15th March 2021

Application No: AW/31/21/HH
Site Address: 3 Haydon Close Aldwick PO21 4LG
Description of works: Single storey rear extension and front porch

Thank you for your internet representation made on 12th March 2021 which has been recorded as an objection with the comments as follows:

Mr. & Mrs. Vitanyi
3 Haydon Close, Bognor Regis
West Sussex PO21 4LG
PROPOSED ELEVATIONS
Date: JAN 2021 Scale 1:100 Dw no. PR.EL 06

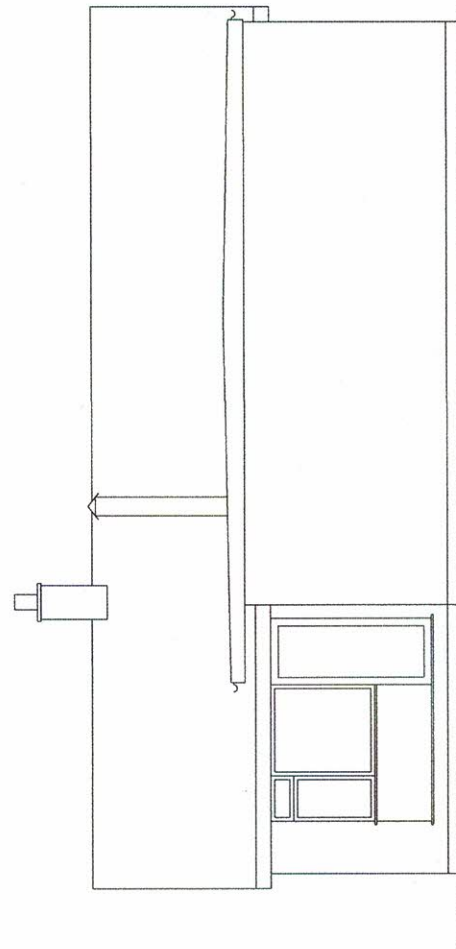
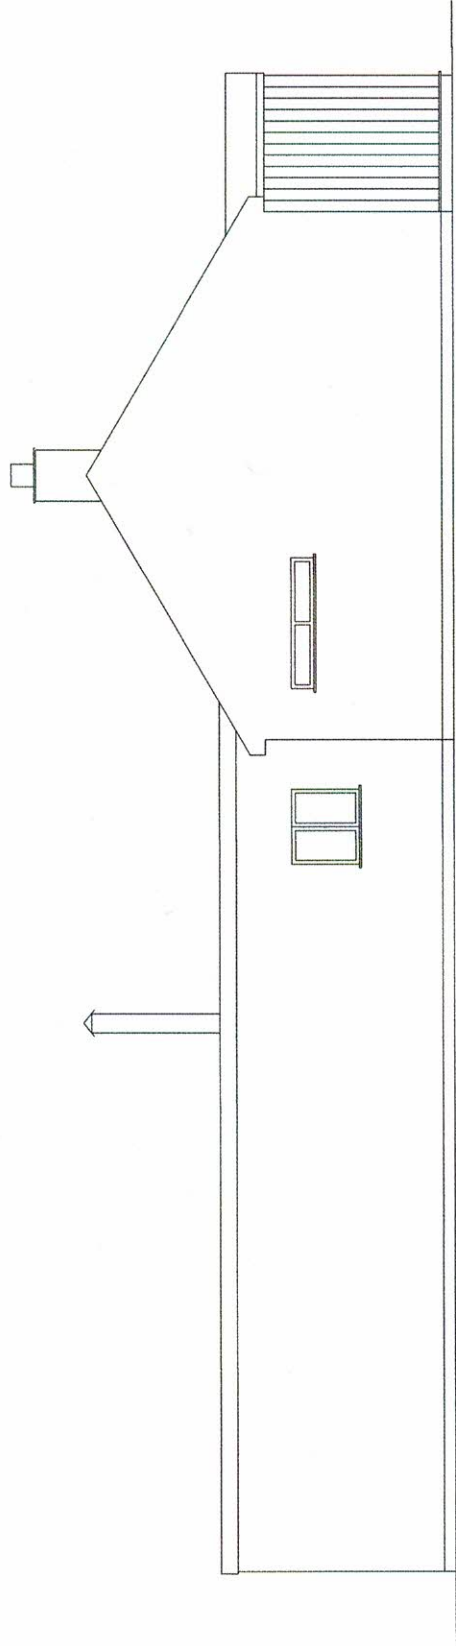
The proposed extension appears to be bigger than the original building and is not in keeping with the other 3 properties in Haydon Close and surrounding areas of Pryors Lane and Willowhale.

The north facing side of the extension would be very close to No.4 and would be higher than the dividing fence. This will cut out sunlight from their garden and create a lack of privacy due to the overlooking window.
